**COLORADO SPRINGS FIRE PREVENTION  
PLAN REVIEW REPORT**

**Tax Id:** DSN: PUDSP194  
**Project Description:** Midtown Collection at Hannah Ridge Filing 2. Lcoated northeast of Constitution Avenue and Peterson Road. CHFD.  
**SYSTEMS:**  
 CN:Code: IBC - IFC - PPRBC /Class: / Const: /Stories: /Size: /OL:  
 FH:Required Flow: gpm /# Hydrants /On site flow:  
 DV: Proposing 89 single family lots on private and public streets.  
 Additional Comments: CHFD Cimarron Hills Fire Department

**Business Name:** **Address:**  
**Plan Id:** 20190974-DV-1 **Plan Description:** DEVELOPMENT PLN  
**Plan Status:** Disapproved **Contractor:** CLASSIC CONSULTING

**FIRE ACCESS ROUTE EXHIBIT**

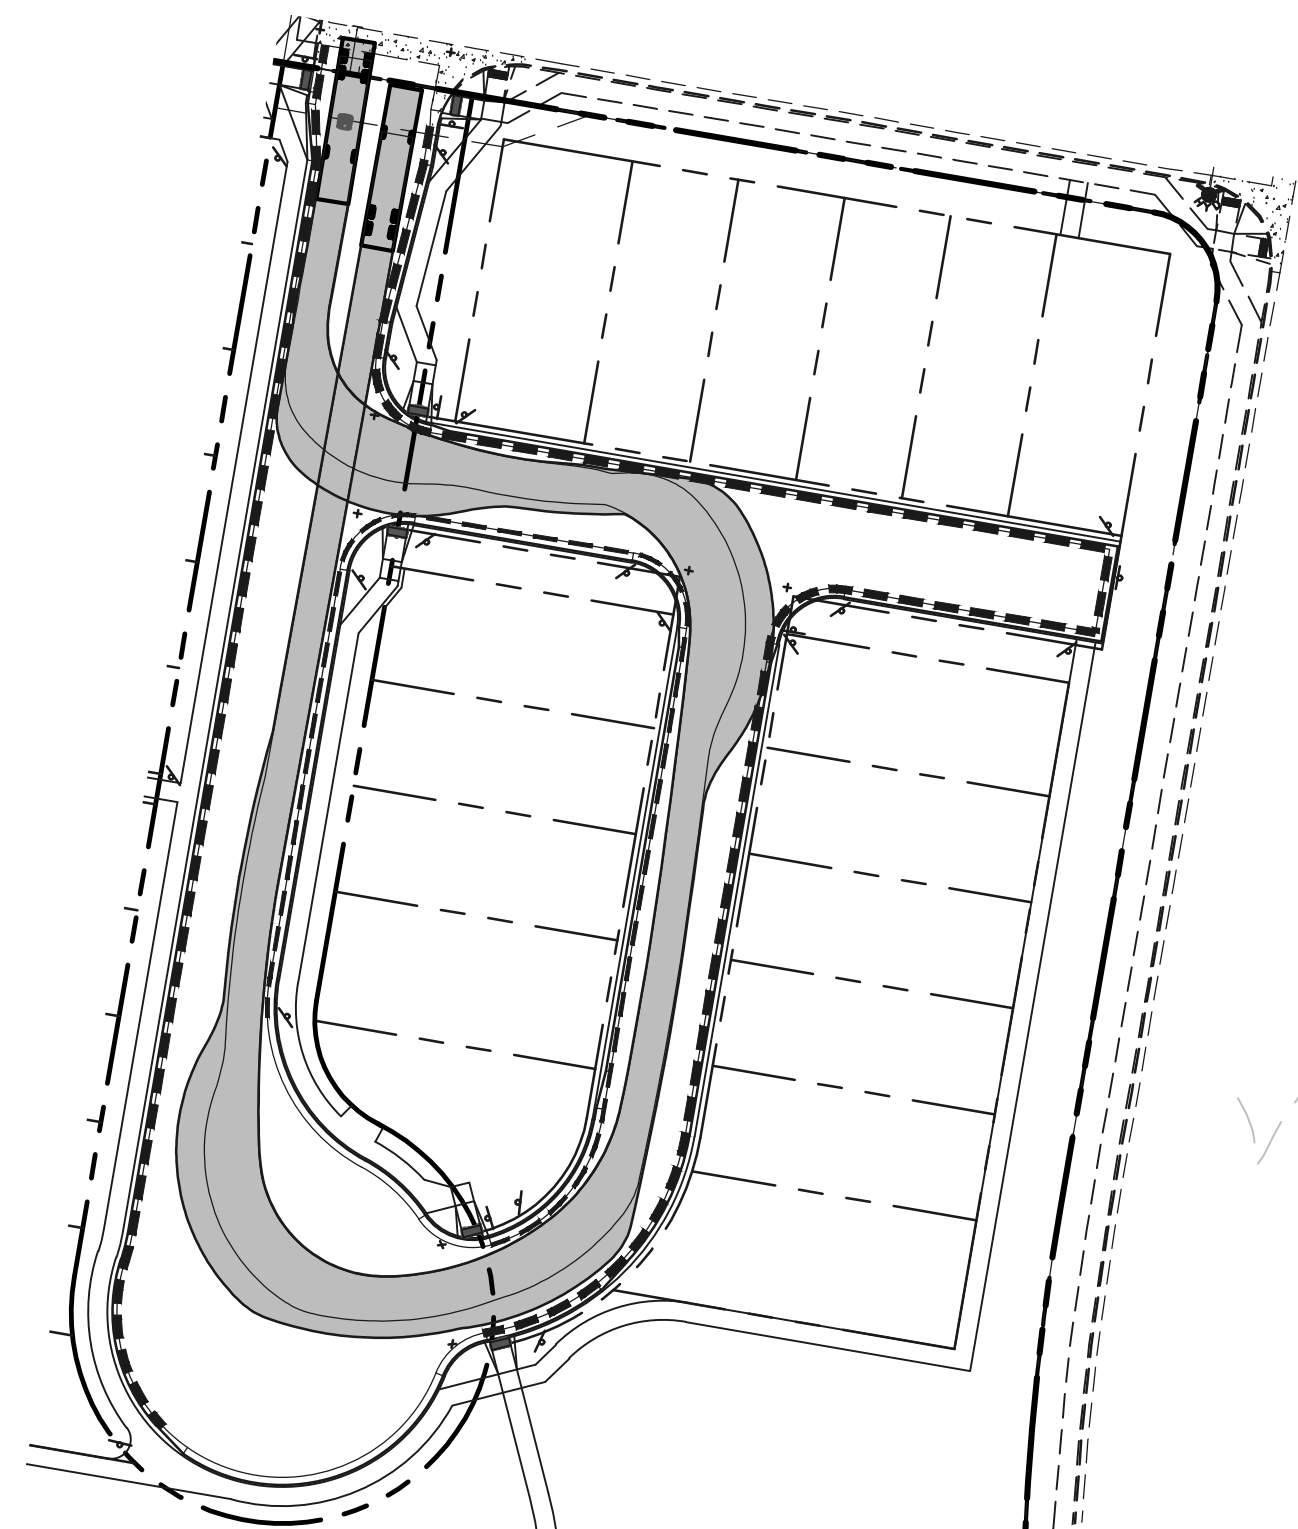
Attention	Approved fire lane markings are required along both sides of Pony Club Lane (not required in the cul-de-sac bulb). This is required to ensure minimum fire code required width of 20-ft for the fire lane is provided. Note this is shown on Sheet 6 of 7 (Street Improvement Signage Plan) of the Construction Drawings uploaded under Filing 2.
Attention	Primary access to Lots 19-24 inclusive is from Zorro Heights and Ghost Rider Way. This is due to the proposed retaining wall between the east side of these lots and Shawnee Drive. Because of this Zorro Heights and Ghost Rider Way will need to meet fire code requiriements. Note this is shown on Sheet 6 of 7 (Street Improvement Signage Plan) of the Construction Drawings uploaded under Filing 2.
Attention	Approved fire lane markings are required along both sides of Ghost Rider Heights and Zorro Heights from the point they intersect with each other back to Pony Club Lane. This is required to ensure minimum fire code required width of 20-ft for the fire lane is provided.
